SUBMISSION FOR ROSEVILLE COLLEGE - NEW SPORT AND WELLBEING CENTRE

Application No: SSD - 9912

Location: 27-29 and 37 Bancroft Avenue, ROSEVILLE, NSW

06  
Elevation  
North & South

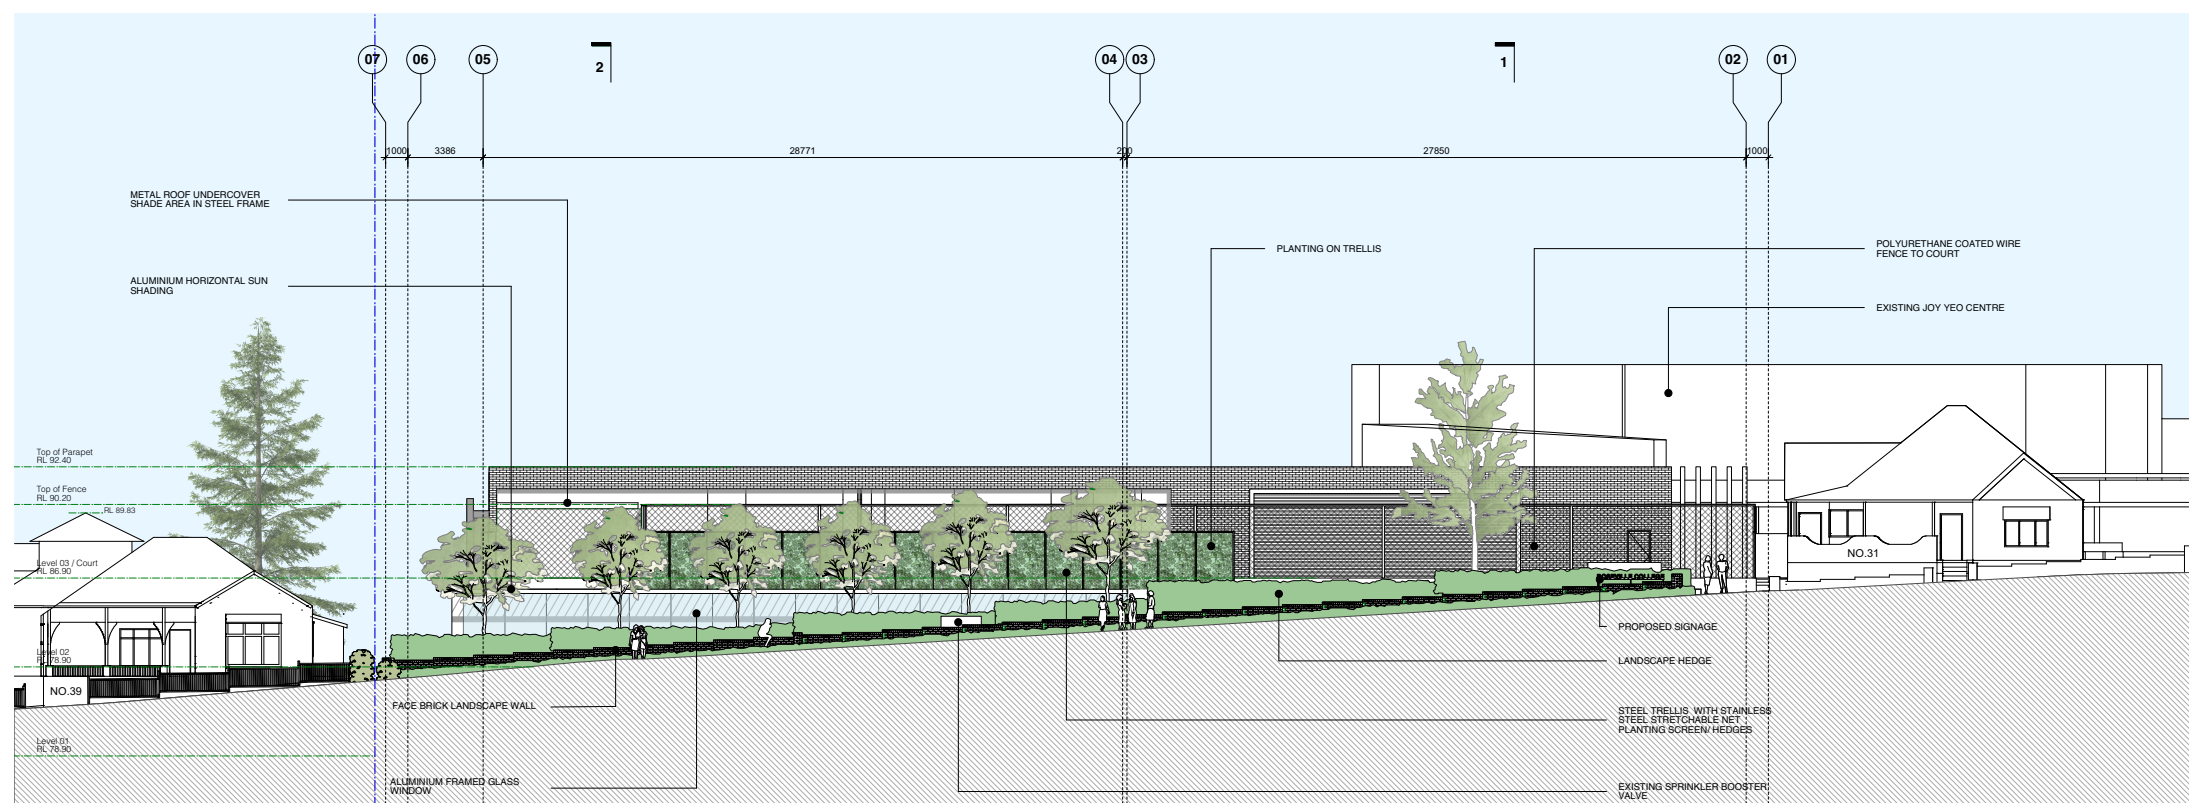
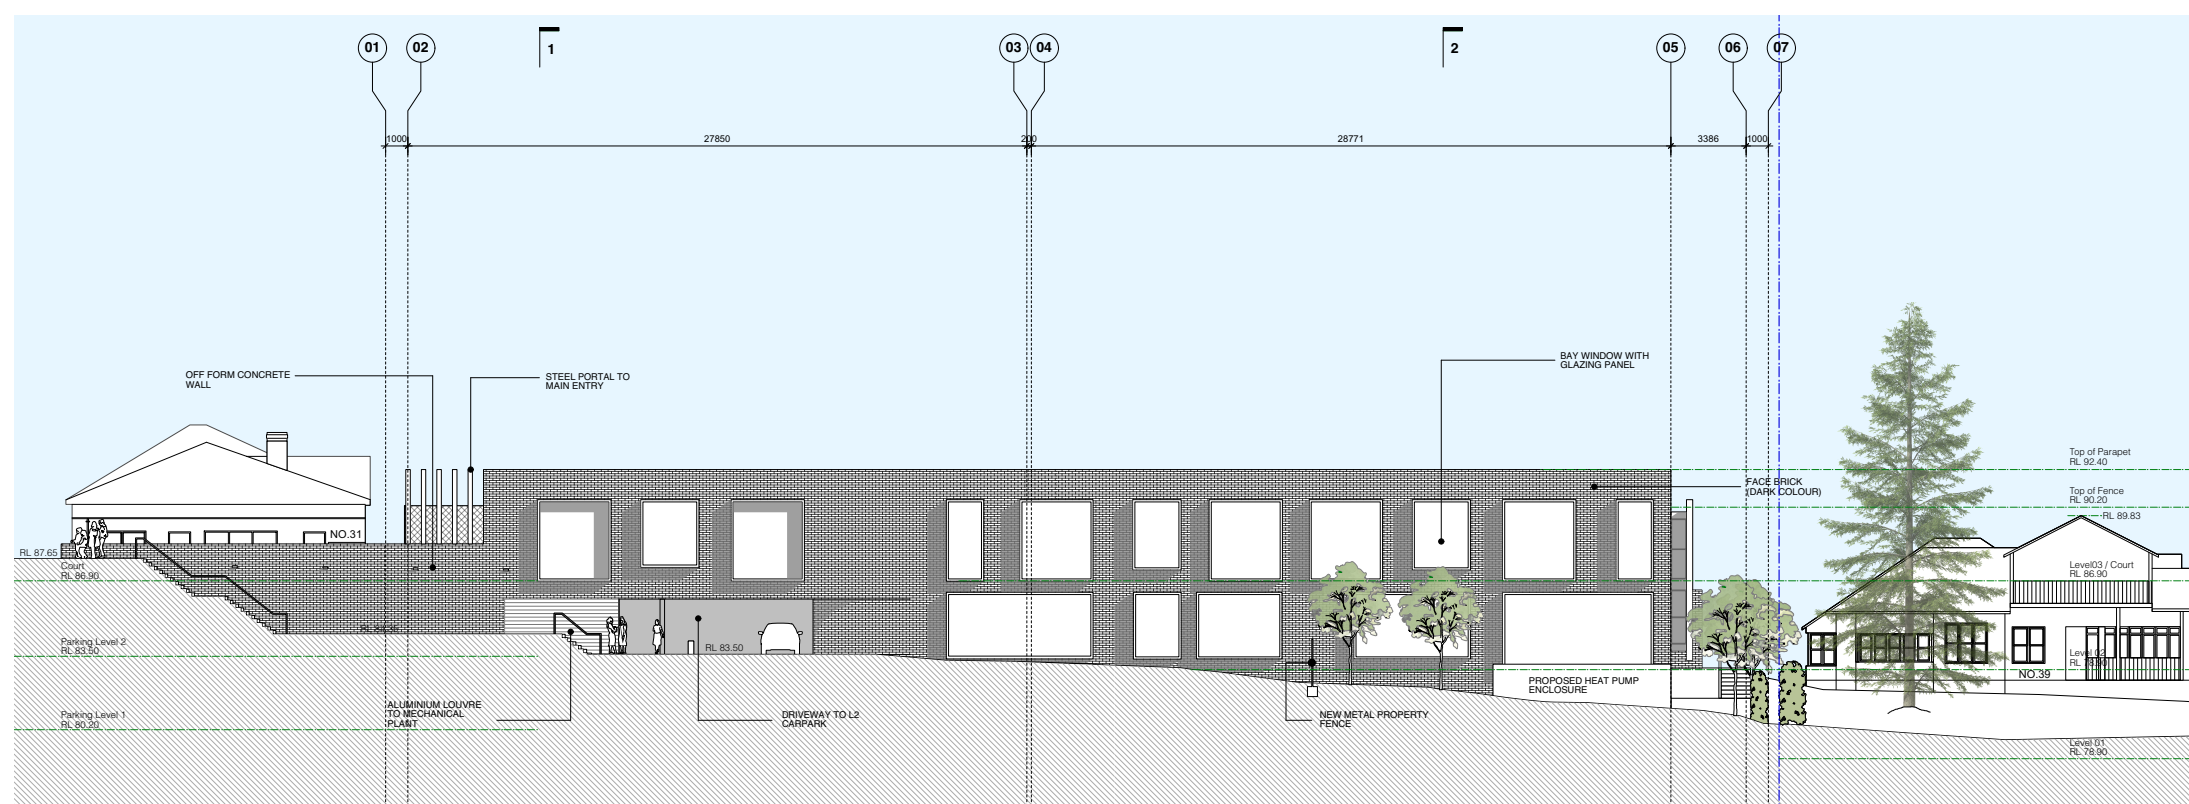
The proposed northern (Bancroft Avenue) facade that is visible in the public space is shown in a number of the reports.

On careful inspection, I realise just how massive this proposed development is. The eastern end, beside 39 Bancroft Avenue, is overwhelming in scale. It towers above the cottage at No 39, dominating and despoiling it in my view. The report explains that the proposed building is closer than allowed in the controls, but that this is excused by more than usual plantings.

I believe this to be unacceptable.

09  
Section 03&04

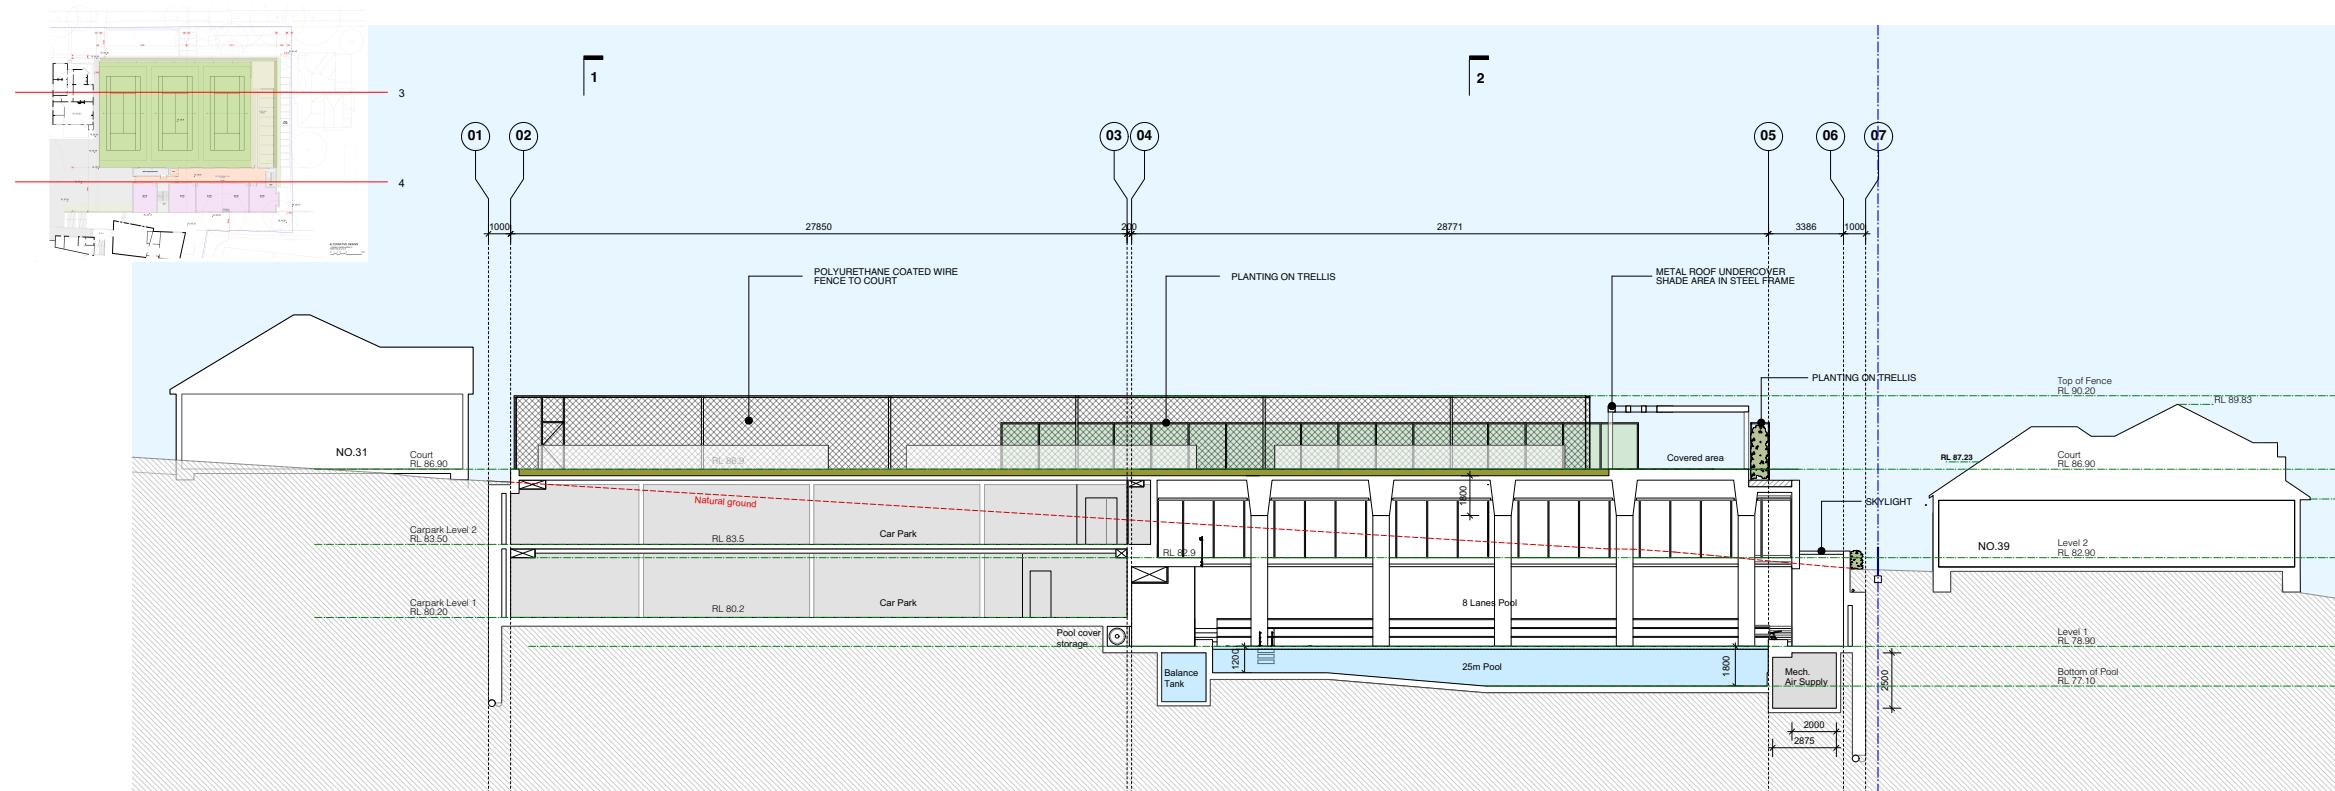
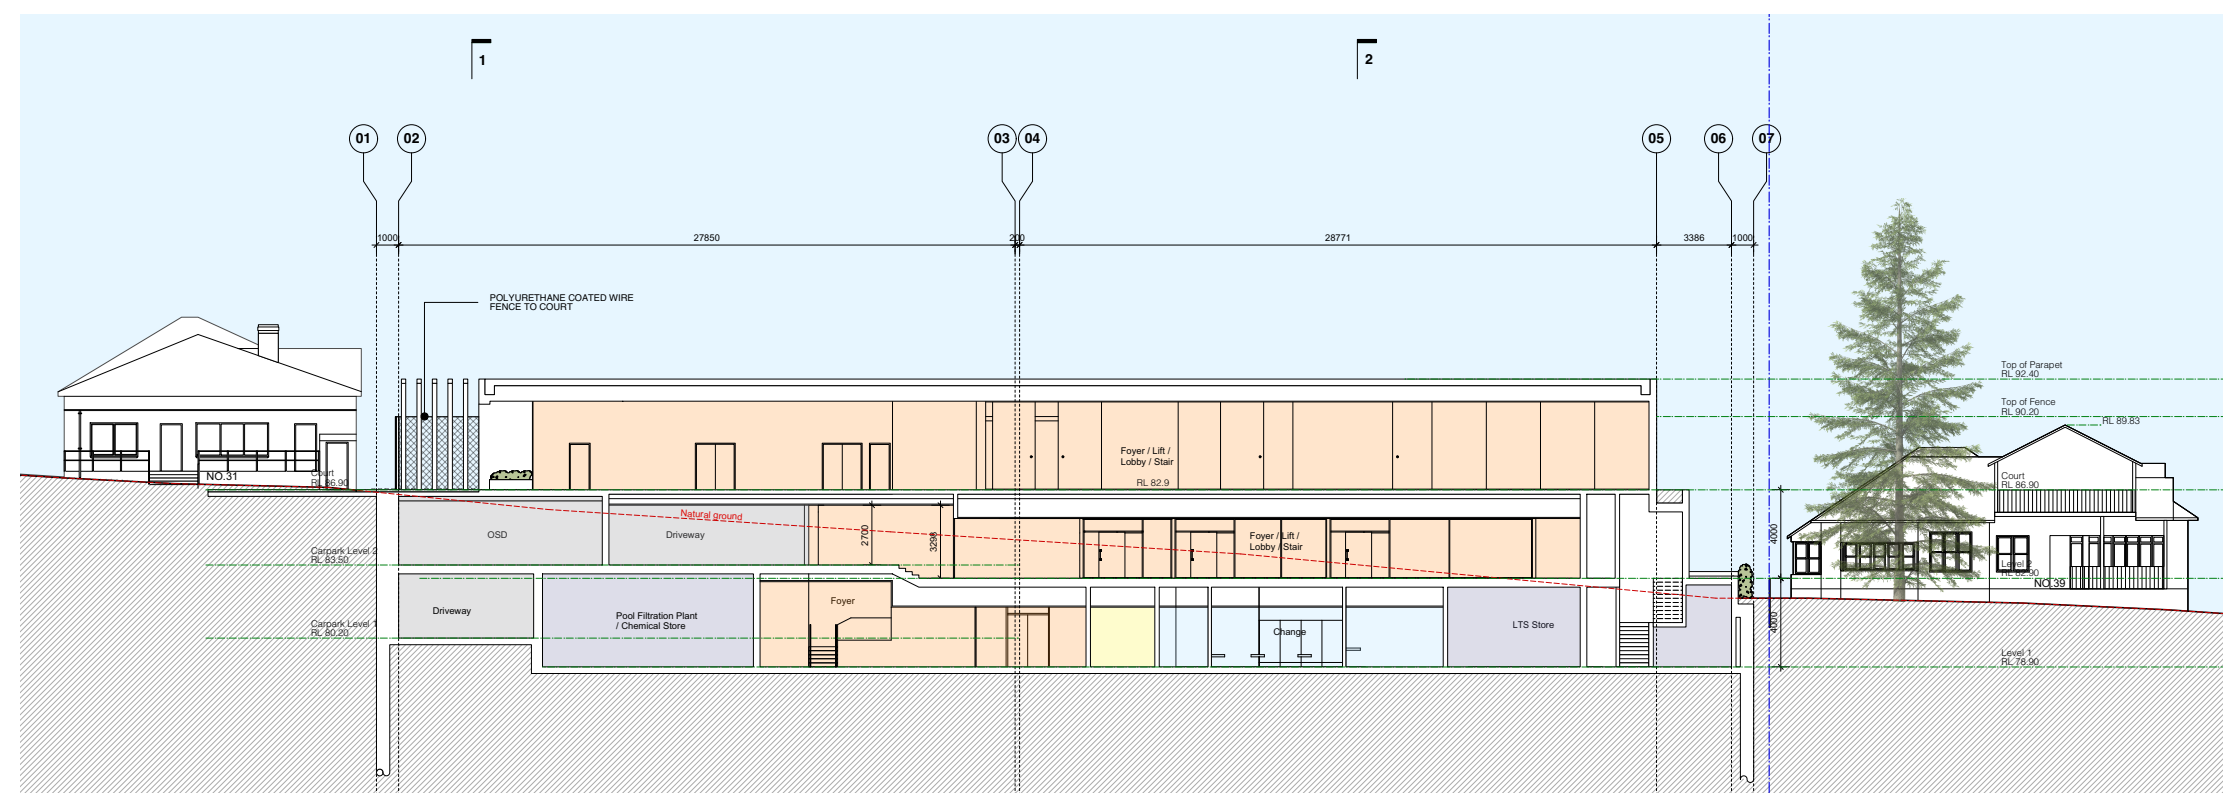
“i) The proposed setback of the development from the adjacent property (39 Bancroft Avenue) is less than the established 12metres. Notwithstanding, the proposed setback and siting of the building is supported from a heritage perspective as the proposed would not detract from the heritage significance of the site. Extensive landscaping is proposed that would mitigate against any undue visual impact. Boundary plantings are proposed, along with vertical greenery and trellis planting on the proposed structure. These proposed landscaping works would ensure the green character, and outlook is retained.”
